Hertfordshire Host Authorities

HERTFORDSHIRE HOST AUTHORITIES' COMMENTS ON ANY FURTHER INFORMATION / SUBMISSIONS RECEIVED BY DEADLINE 5

London Luton Airport Expansion

DATE: DECEMBER 2023

Figure 32 Growth in trip productions by mode in NTEM 8 and NTEM 7.2

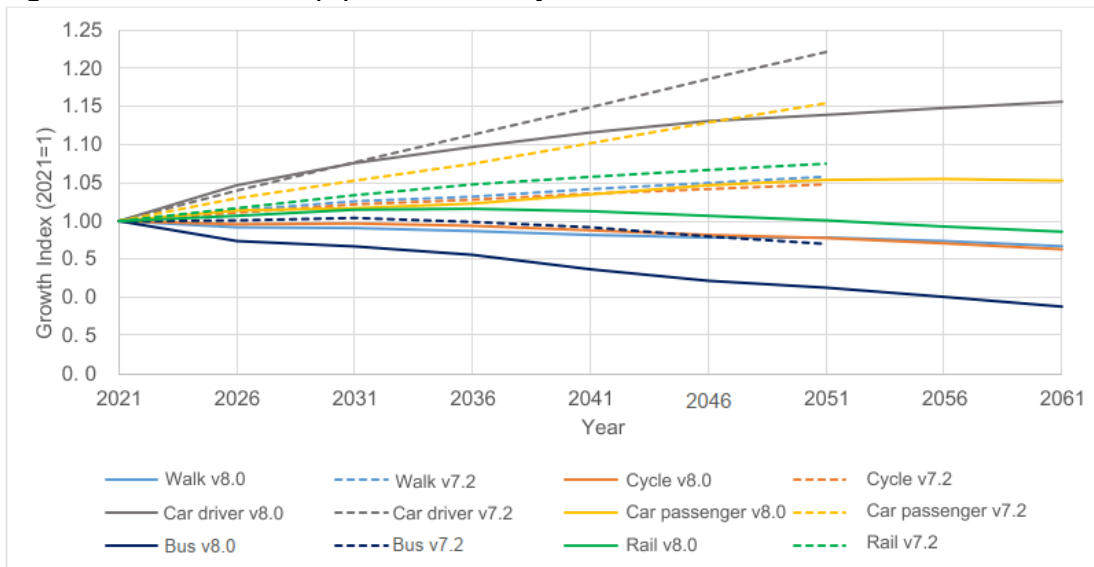
Reference	Topic	Matters Raised	Hertfordshire Host Authorities Comment
28	Surface Access (Modelling)	The Applicant should confirm whether this graph is showing National or Local Growth Productions by mode.	The Applicant should provide comparisons of the National data against the local data (Luton and HCC) for National Trip End Model (NTEM) 7.2 and NTEM 8.
29	Surface Access (Modelling)	The Applicant should confirm whether this graph is showing National or Local Growth Productions by mode.	The Applicant should provide comparisons of the National data against the local data (Luton and HCC) for NTEM 7.2 and NTEM 8.
30	Surface Access (Modelling)	The Applicant should confirm whether this graph is showing National or Local Growth Productions by mode.	The Applicant should provide comparisons of the National data against the local data (Luton and HCC) for NTEM 7.2 and NTEM 8.
31	Surface Access (Modelling)	<i>“Demand model and highway assignment model runs taking place for reporting in October, including new 2023 forecast year and comparison with count data.”</i> The Applicant should confirm the methodology adopted to produce the 2023 forecast matrices.	The Applicant should clarify how the 2023 forecast year has been developed. There is insufficient information on this in the Applicant’s Response to Issue Specific Hearing 4 Action 2: Covid 19 [REP4-106] . The Applicant should clarify how the outcomes in the Applicant’s Response to Issue Specific Hearing 4 Action 2 - Covid 19 Additional Modelling Technical Note 1 [REP4-086] have been taken into consideration in the 2023 forecast.
